SCOTTISH POWER – EAST ANGLIA ONE NORTH AND EAST ANGLIA TWO

REFS – 20024254 & 20024255

WRITTEN REPRESENTATIONS ON BEHALF OF
MICHAEL MAHONY, [REDACTED]

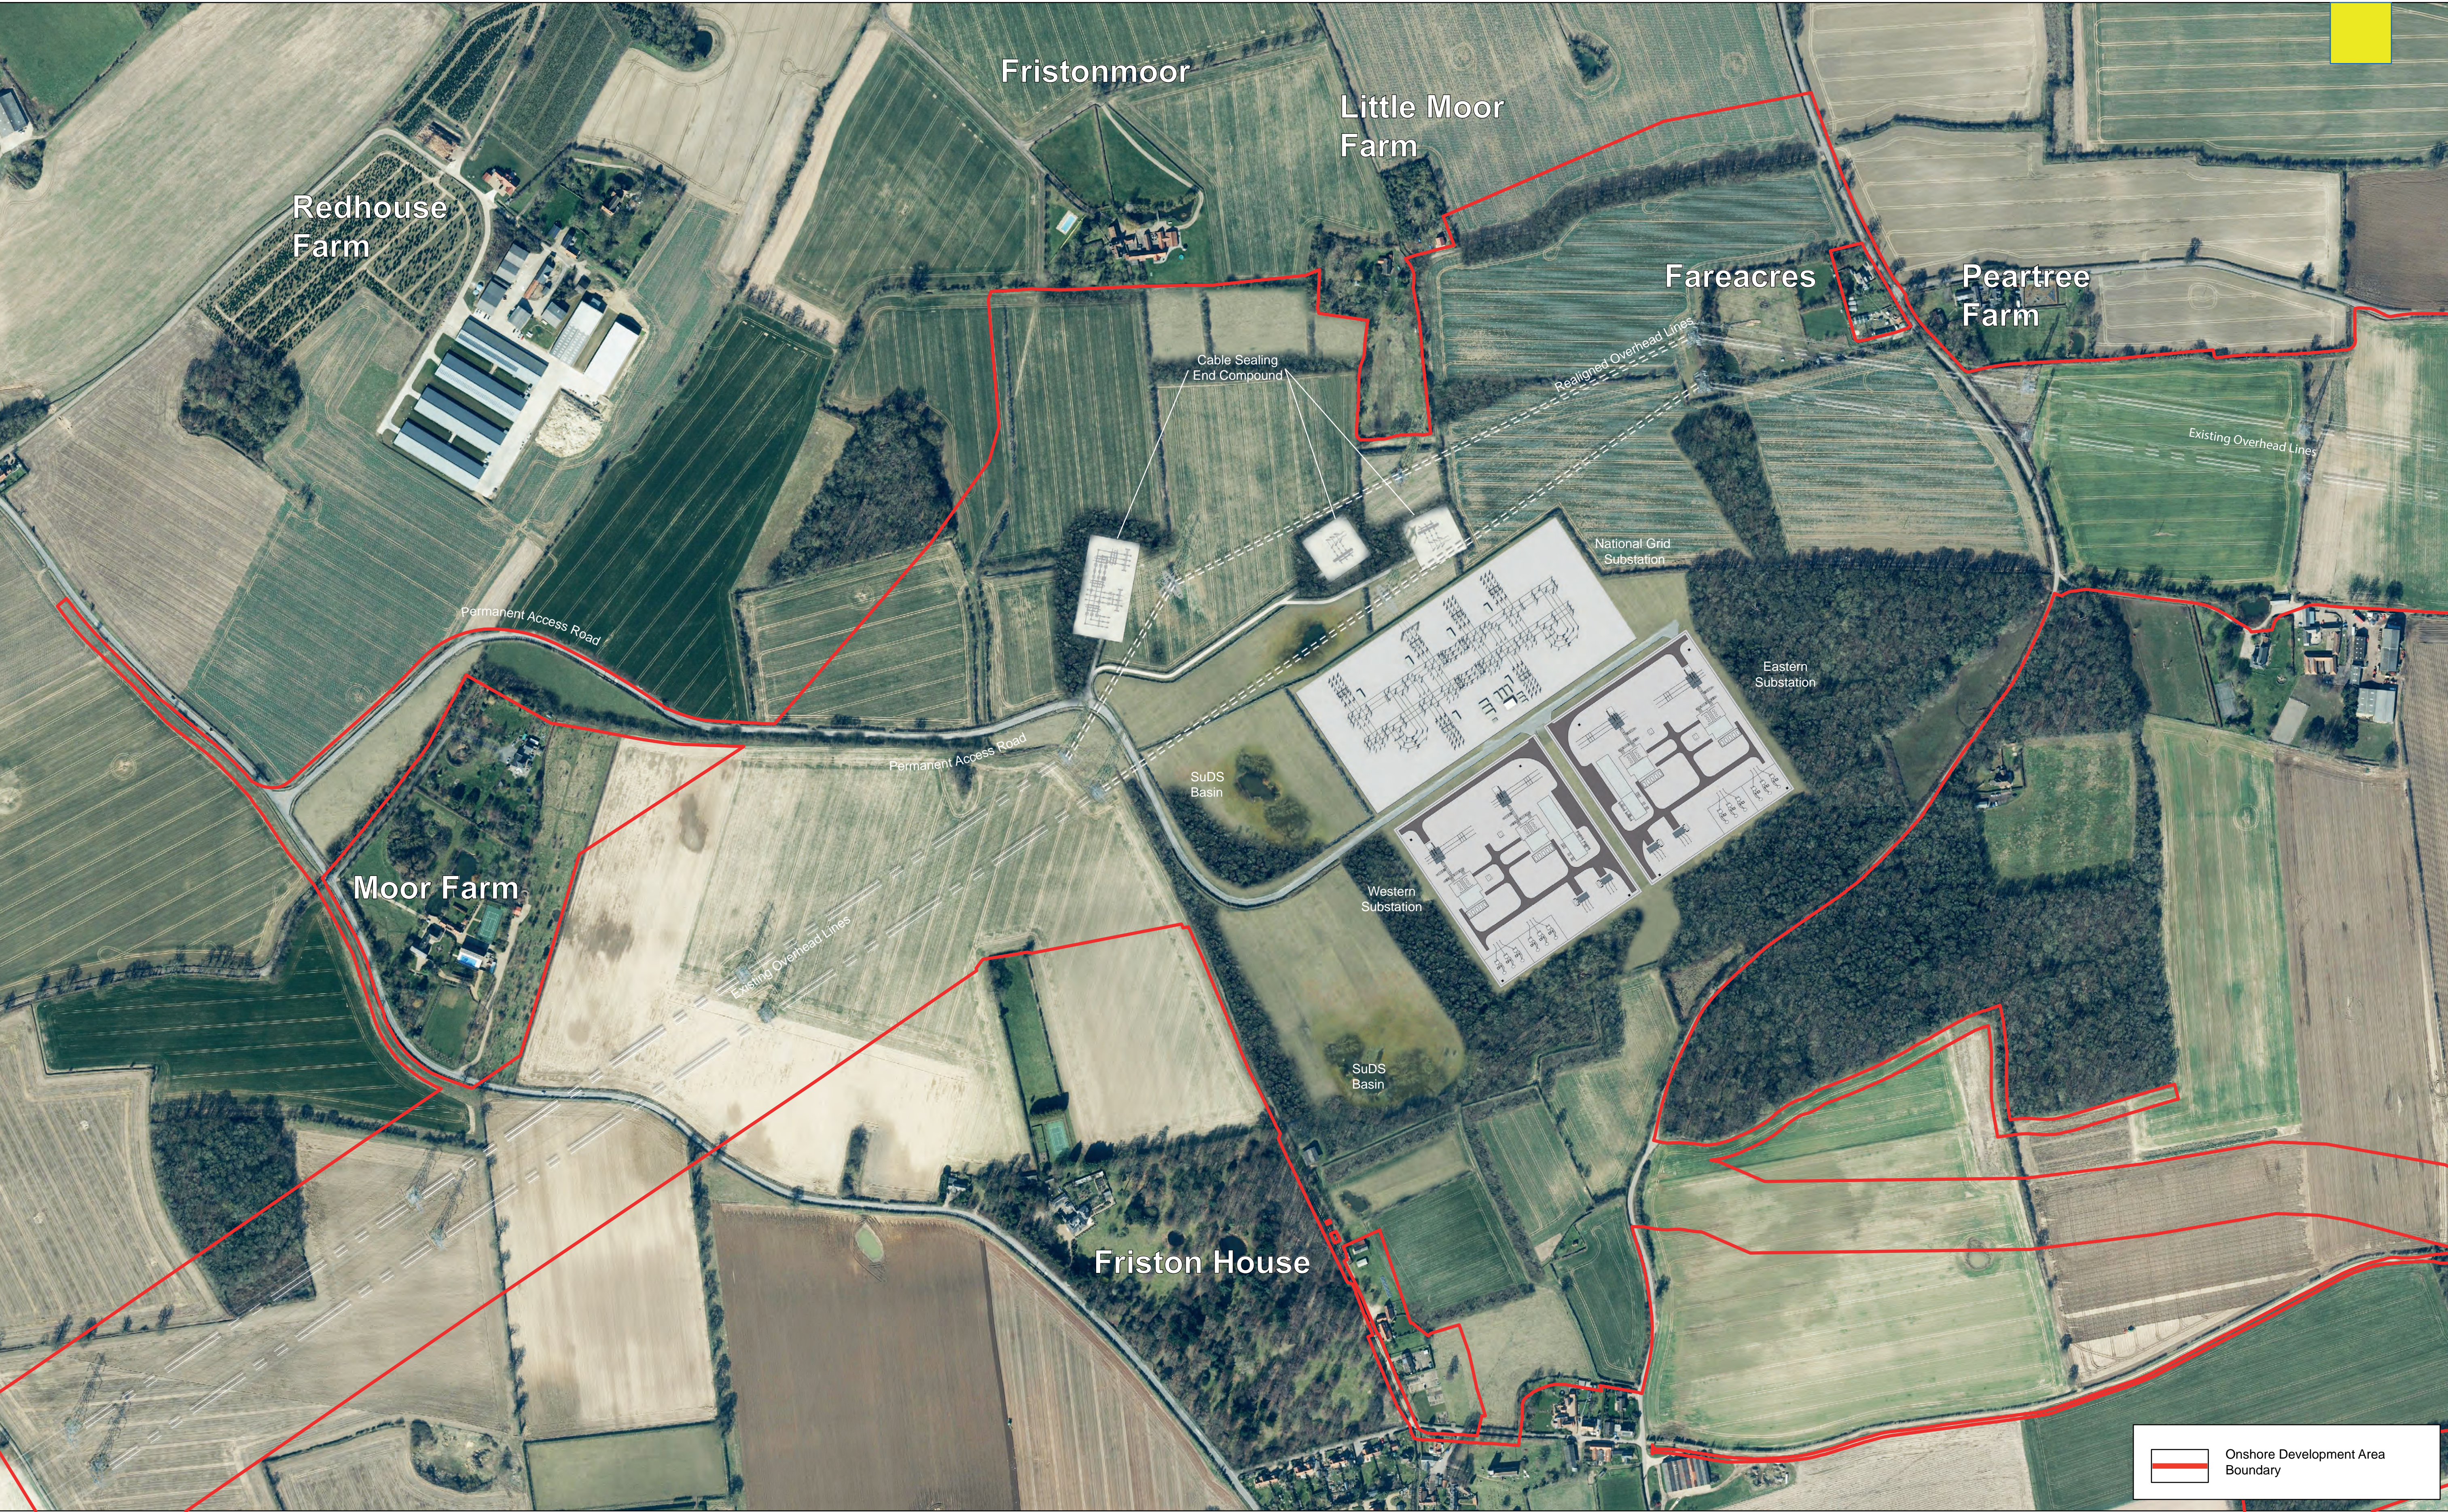
- 33. I also wish to make representations in respect of the Applicant's plans for landscaping in the north eastern corner of Plot 115, as shown on Figures 29.11a, 29.11b and 29.12 of the Applicant's Environmental Statement.²⁵ All three of these drawings show a gap in the

hedgerow in this corner of the field. Figure 29.11a depicts this area as grassland. In fact, as is apparent from Image 1 (above) and will be even more apparent following a site visit, there is an existing hedgerow in this area – indeed the whole of the Agricultural Land is bordered by an established hedge albeit with a few gaps. The Applicant should be required to re-instate this hedgerow in its entirety at the conclusion of any works. Figure 29.12 suggests that a pre-construction hedgerow will be planted here. However, this cannot be correct because the Applicant intends to use this corner of the Agricultural Land to access Plot 115. Further, given the soil and weather conditions in Suffolk (particularly the dry summers), the Applicant should be required to adhere to a maintenance regime to ensure that the replacement hedgerow becomes established quickly and that any fell planting is remedied without delay.
